Reference Number: H16-1096-23

Our ref: AN/2023/135168/02-L01
Your ref: H16-1096-23
Date: 14 February 2024

**Proposed anaerobic digester plant
Land Between A16 And Rangell Gate Spalding**

Figure 10 - Foul Connection into Matmore Gate

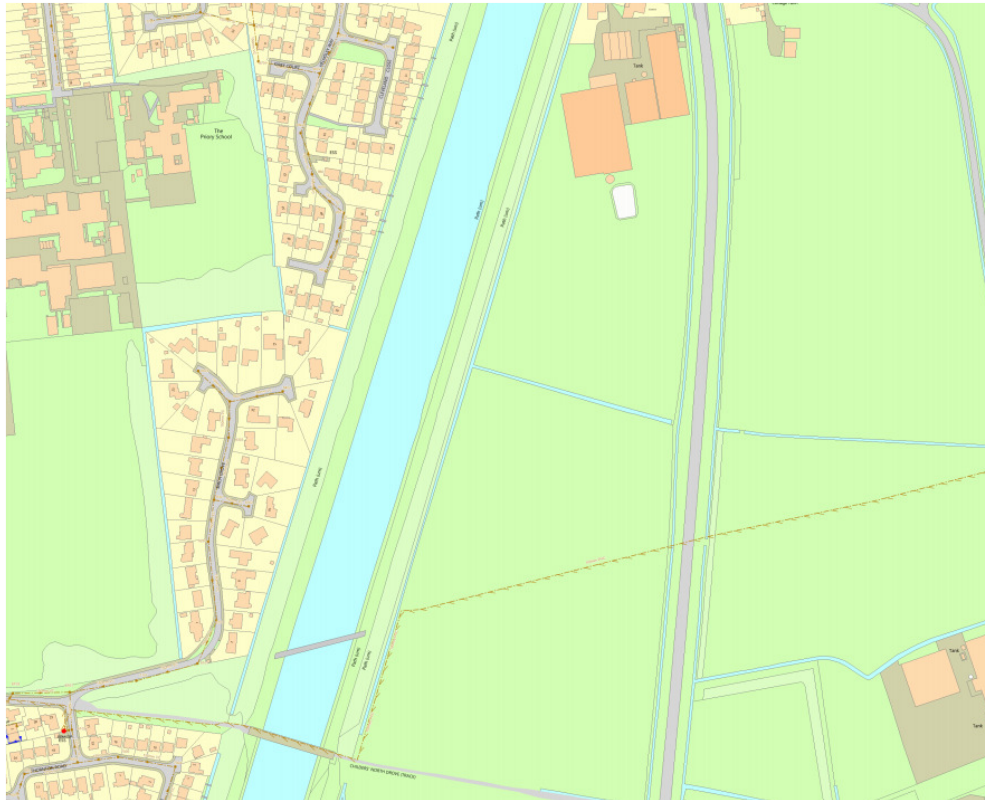
The 'Statement on Odour Control' undertaken by Waste Powers, uploaded on 01 February 2024 does not satisfactorily address our earlier concerns on foul drainage.

In this instance no justification has been provided by the applicant for non-connection to the mains sewerage system.

To overcome our objection the applicant should thoroughly investigate the possibility of connecting to the public foul sewer, and either revise their application to propose a mains connection or submit evidence that demonstrates that this is not feasible.
